RE: 4 Murray Rose Avenue Sydney Olympic Park

This report is prepared for Lend Lease Building Pty Ltd in support of a S96 Application for the 4 Murray Rose Avenue site.

I refer to your request to undertake a compliance check for the design of the multi-storey internal car park at 4 Murray Rose Avenue, Sydney Olympic Park. The subject of this check is the full extent of the car park on the Basement 01, Basement 02 and Basement 03 Levels, and the access arrangements and loading dock on the Ground Level as identified on Turner's drawings 12022-EA103.a-S, 12022-EA102-S, 12022-EA101-S and 12022-EA104-X.

Project Title
4MR
4 Murray Rose Avenue SOP NSW 2127 AU
Drawing Title
PLANS
Basement 03

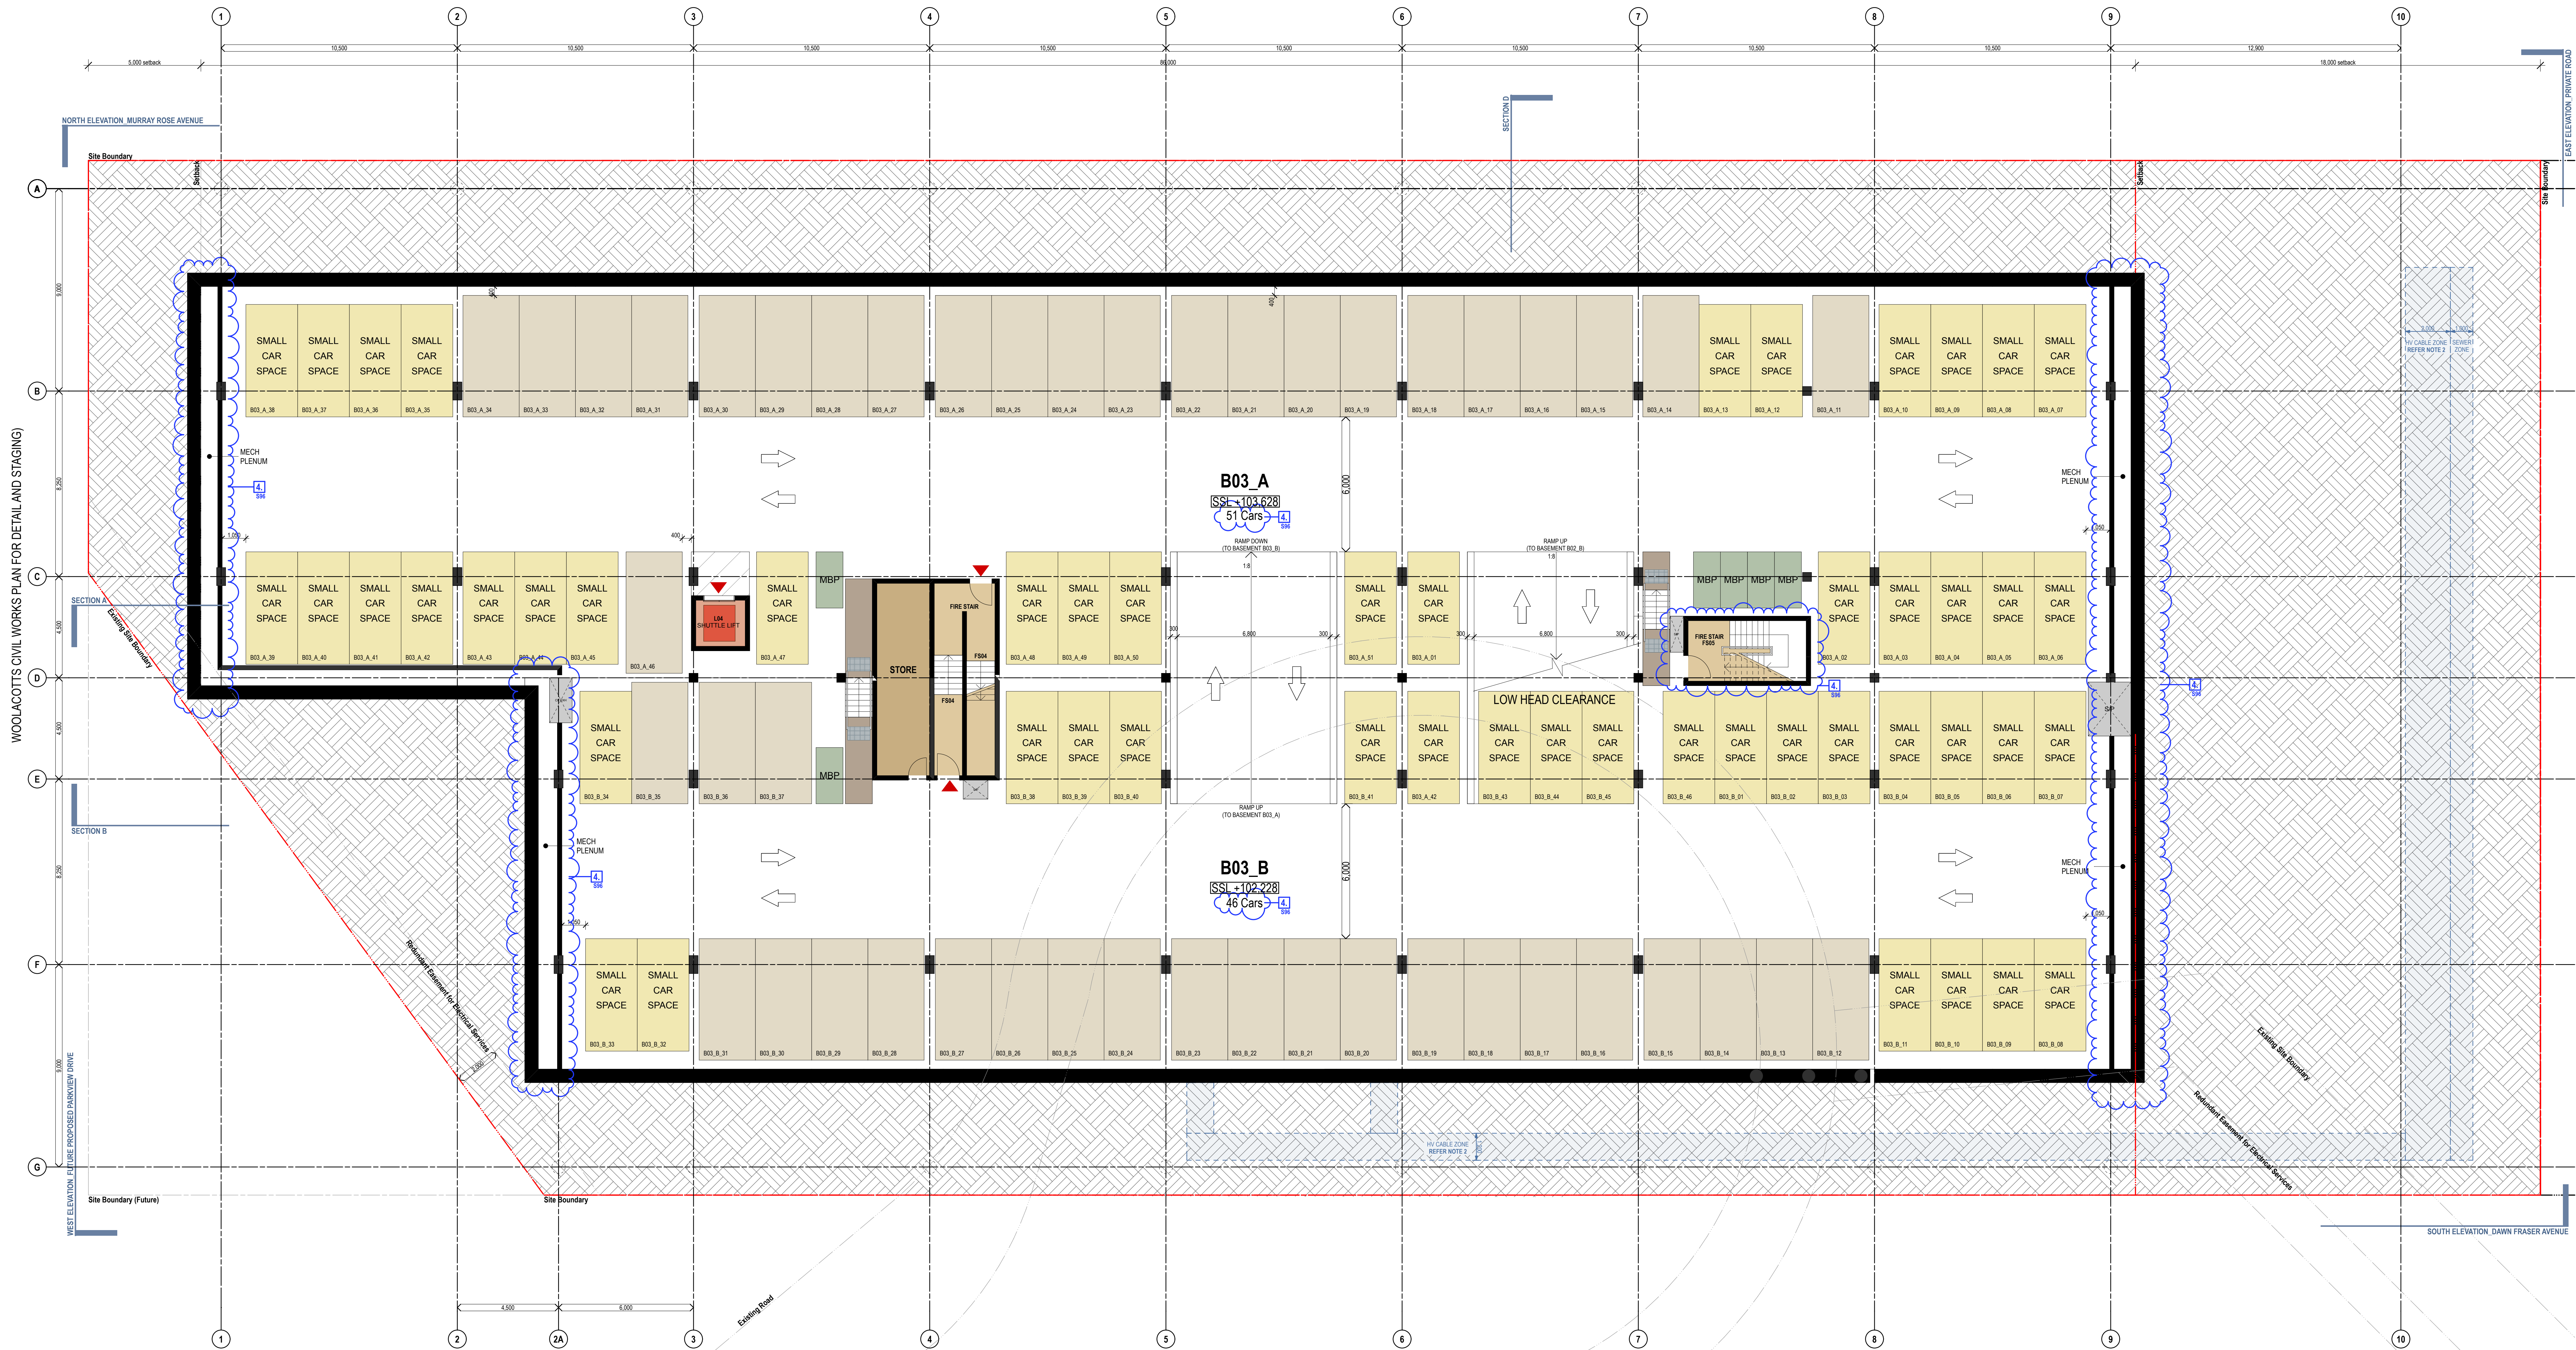
The full extent of the car park and loading dock, as identified on Turner's drawings 12022-EA103.a-S, 12022-EA102-S, 12022-EA101-S and 12022-EA104-X, have been assessed against the requirements of off-street car parking specified in Australian Standards AS2890.1:2004 and AS2890.6:2009. The layout of the proposed car park and loading dock are designed in accordance with AS2890. While the height clearance of the loading dock is less than the AS2890.2 requirement of 4.5m, it exceeds the 3.8m stipulated in the brief.

Low Clearance signage to AS1742 is required to warn drivers of height clearance lower than 4.6m. Consideration should be given to provision of a low clearance warning gauge or flexible barrier in advance of the loading dock as a further warning of the height clearance.
